To: [DCAdmin](#)
Subject: Comments in response to - Planning Application 2019/91327 - Thongsbridge Mills - FAO Mr Glenn Wakefield
Date: 12 June 2019 14:42:54

Re: Planning Application 2019/91327 - Thongsbridge Mills

Appendix 1. Landscape Design Showing Areas of Native Planting

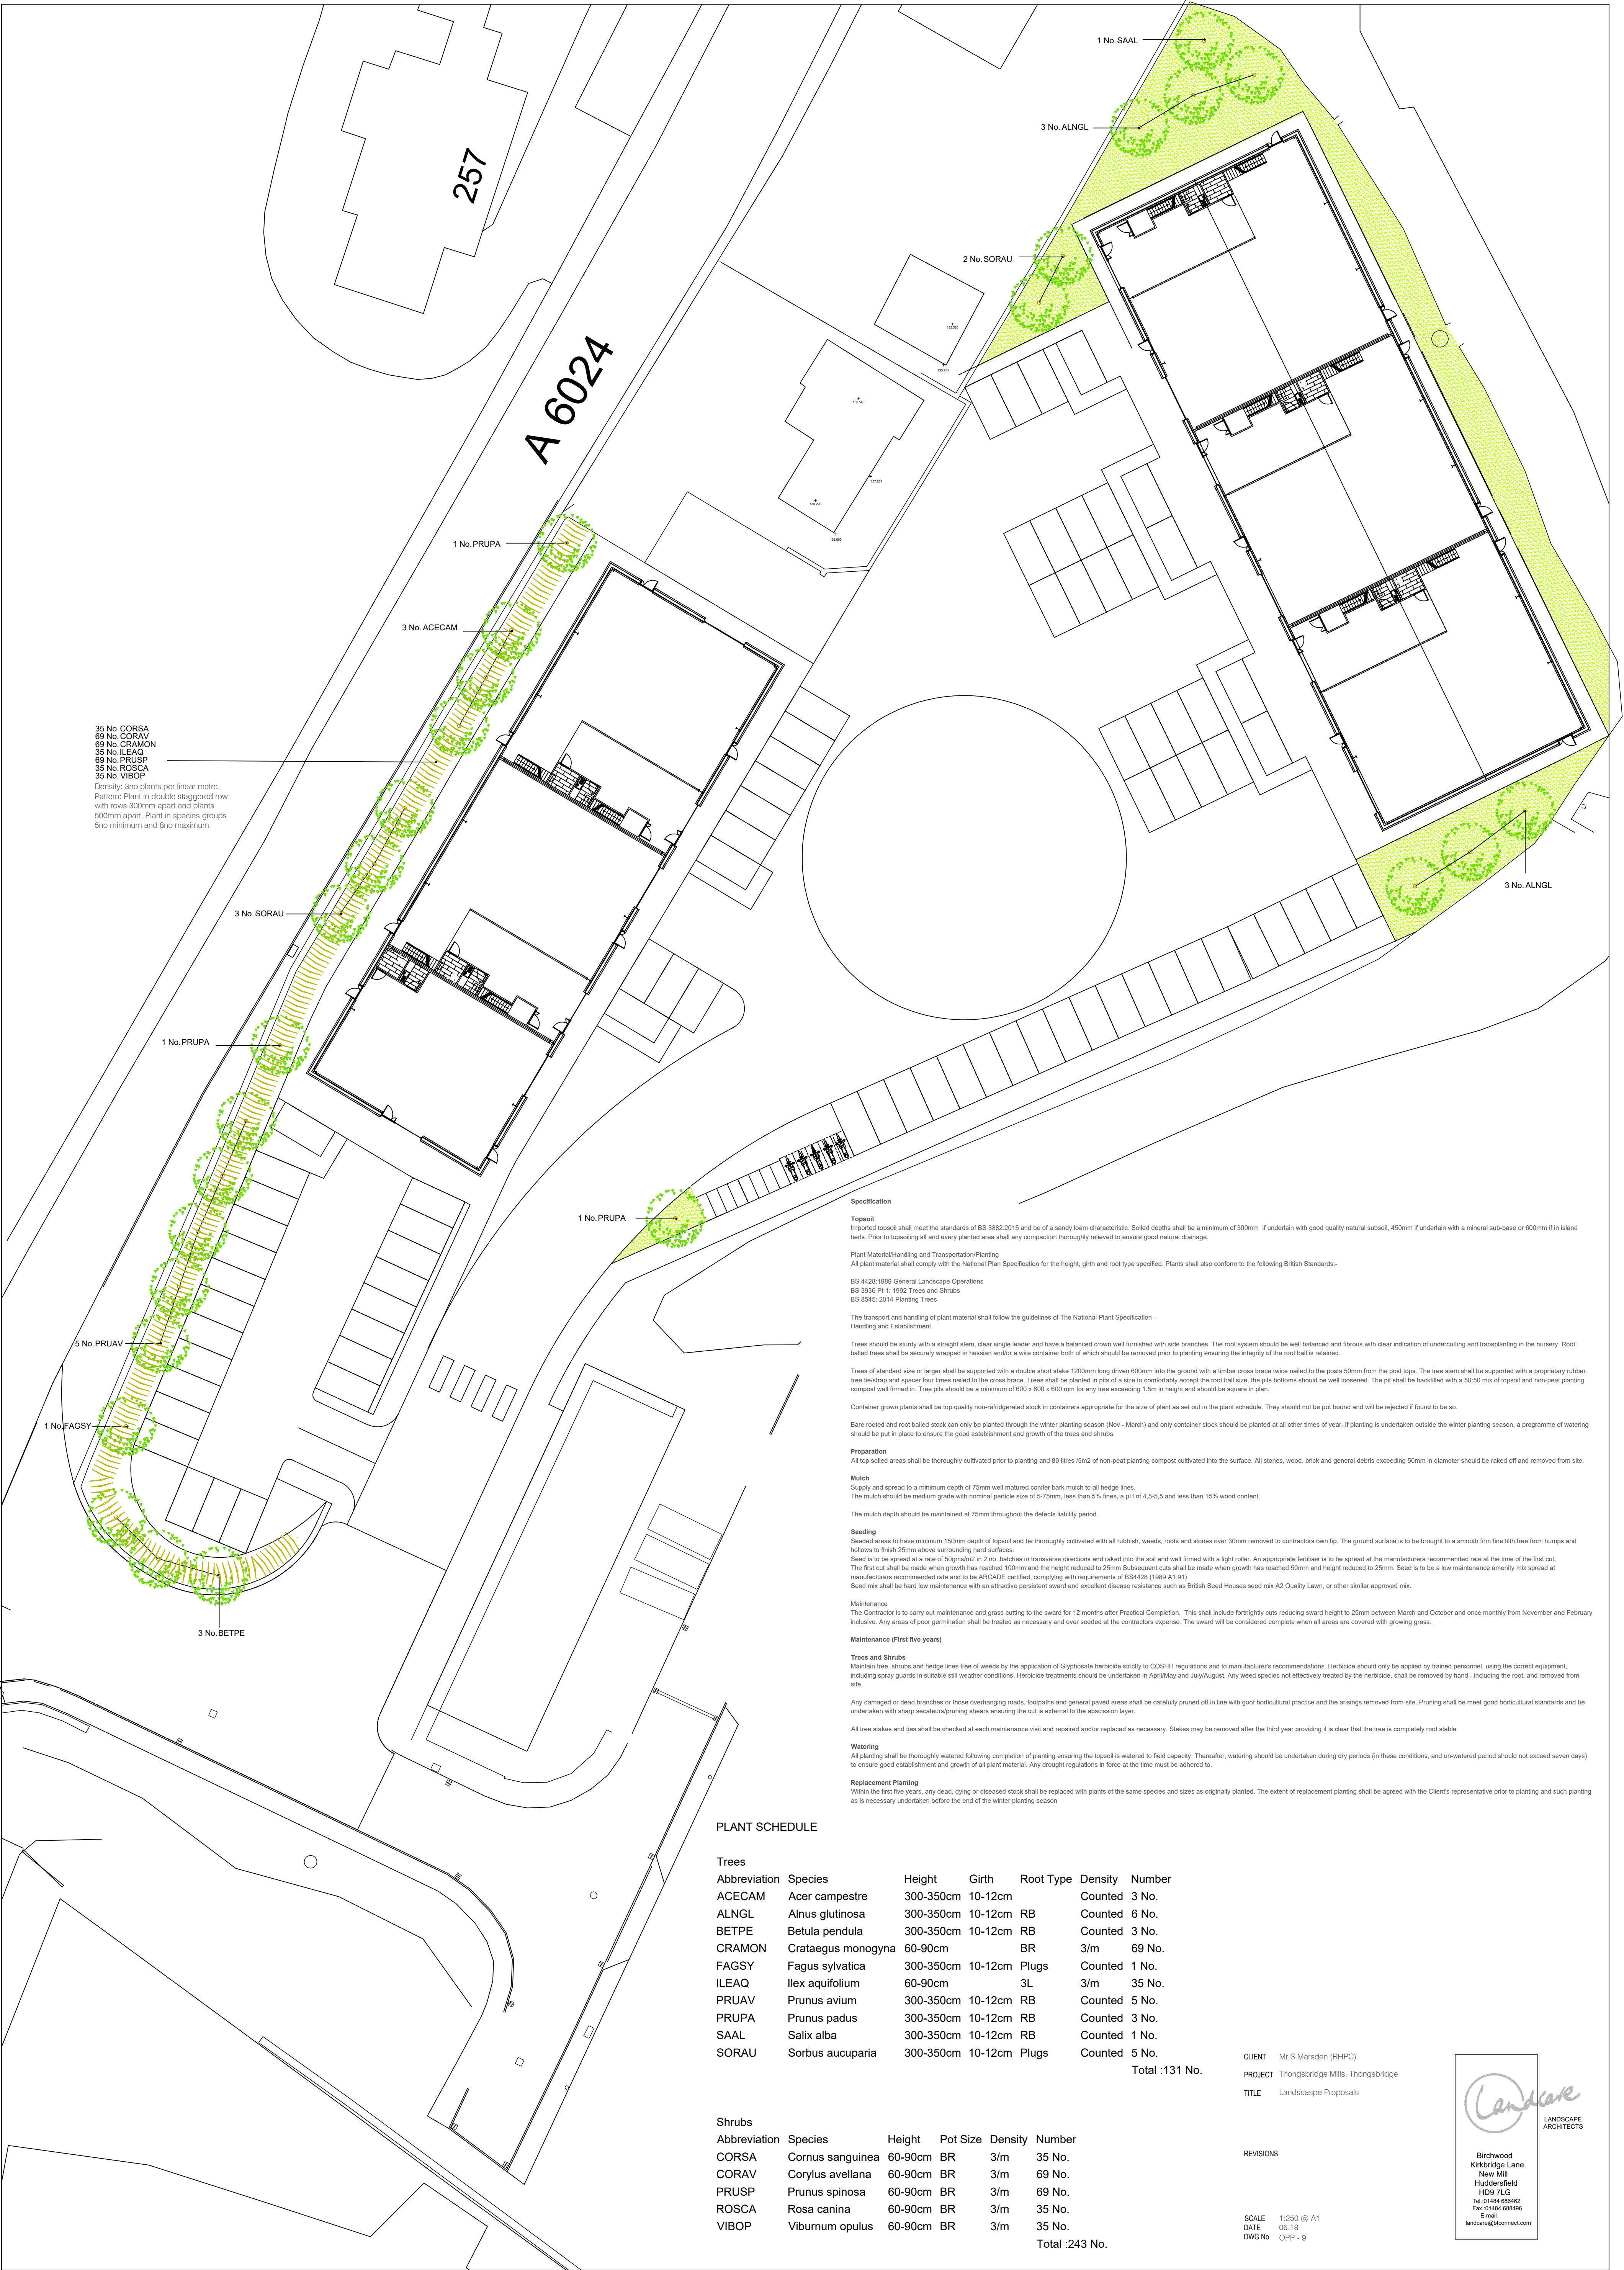
1. A barrier between us and the proposed site.

- Either in the form of a fence, of suitable height and appearance, or trees, preferably ever green.
- We note that a barrier of trees has been proposed to screen the site from residents on Huddersfield road, but no such barrier has been proposed for the row of terrace houses,
